**KIRKLEES METROPOLITAN COUNCIL
INVESTMENT & REGENERATION SERVICE**

DELEGATED DECISION TO DETERMINE PLANNING APPLICATIONS

Reference No:	2026/62/91044/E
Site Address:	2, Bonaccord Square, Batley, WF17 7QG
Description:	Erection of front porch and first floor rear extension
Recommending Officer:	Jennifer Booth

DECISION – REFUSED

PROPOSED FIRST FLOOR PLAN

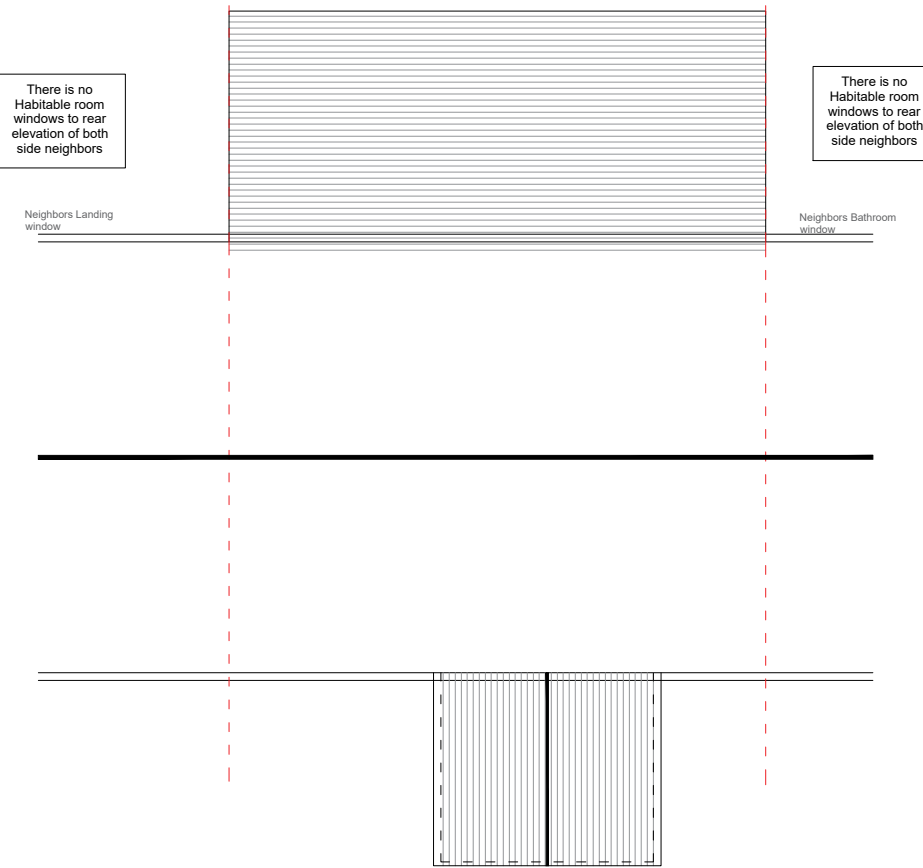
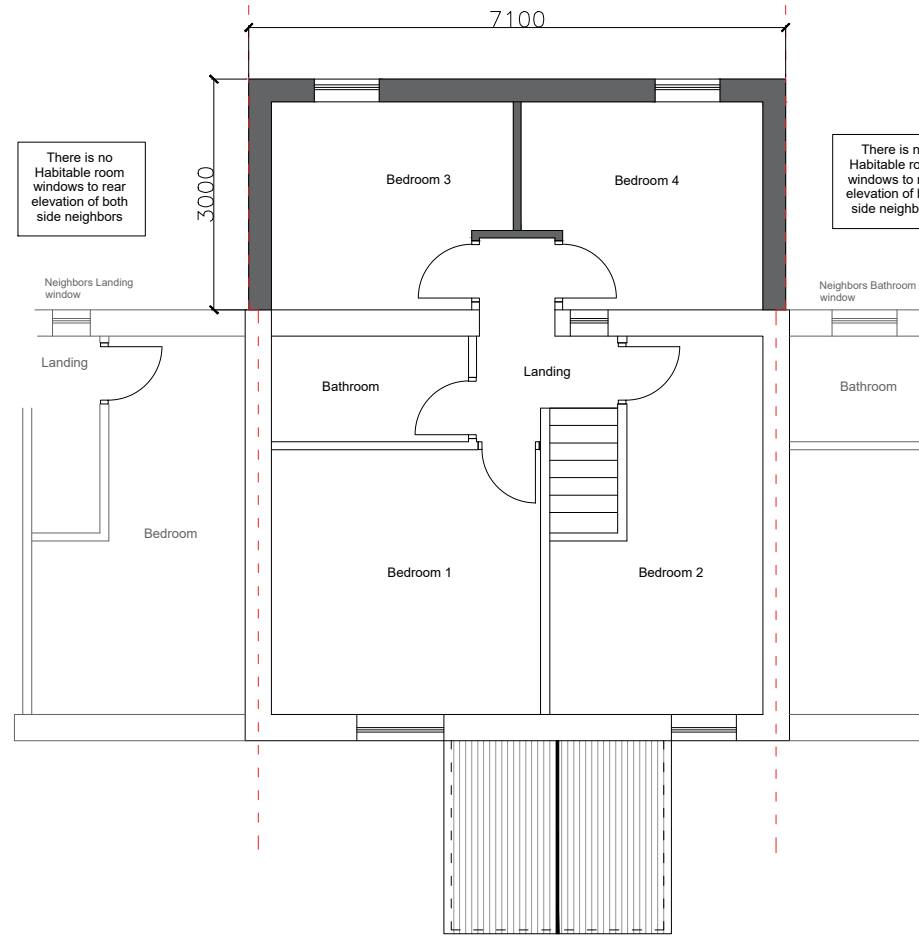
The proposed development is considered to result in unacceptable impacts on the residential amenity of neighbouring occupants to the rear at 20 and 22 Denison Street. Whilst the surrounding area is characterised by a relatively dense urban form, the relationship between the application site and these properties, with limited separation distances of approximately 4.4m at ground floor level and around 7.5m at first floor level, heightens sensitivity to additional built form. In this context, the proposals would materially intensify

the sense of enclosure and intervisibility, giving rise to increased overlooking, an overbearing presence, and undue overshadowing beyond the existing baseline conditions. The intended use of obscure glazing to serve bedrooms is noted however the close proximity of these openings would give rise to a sense of overlooking for occupiers of nos. 20 and 22. As such, it is considered that the proposal would erode the current standard of residential amenity experienced by occupiers of neighbouring properties to the rear to an unacceptable degree.

The proposed development, by reason of its siting, scale, and proximity to the shared boundaries with neighbouring properties at 20 and 22 Denison Street, would result in an unacceptable impact on the residential amenity of these occupiers. In particular, the development would give rise to increased overlooking, overbearing and undue overshadowing, exacerbating the already constrained relationship between the properties. This would materially worsen the living conditions of neighbouring residents, contrary to Policy LP24 of the Kirklees Local Plan, KDP3, 5 & 6 of the House Extensions & Alterations SPD and policies within Chapter 12 of the National Planning Policy Framework.
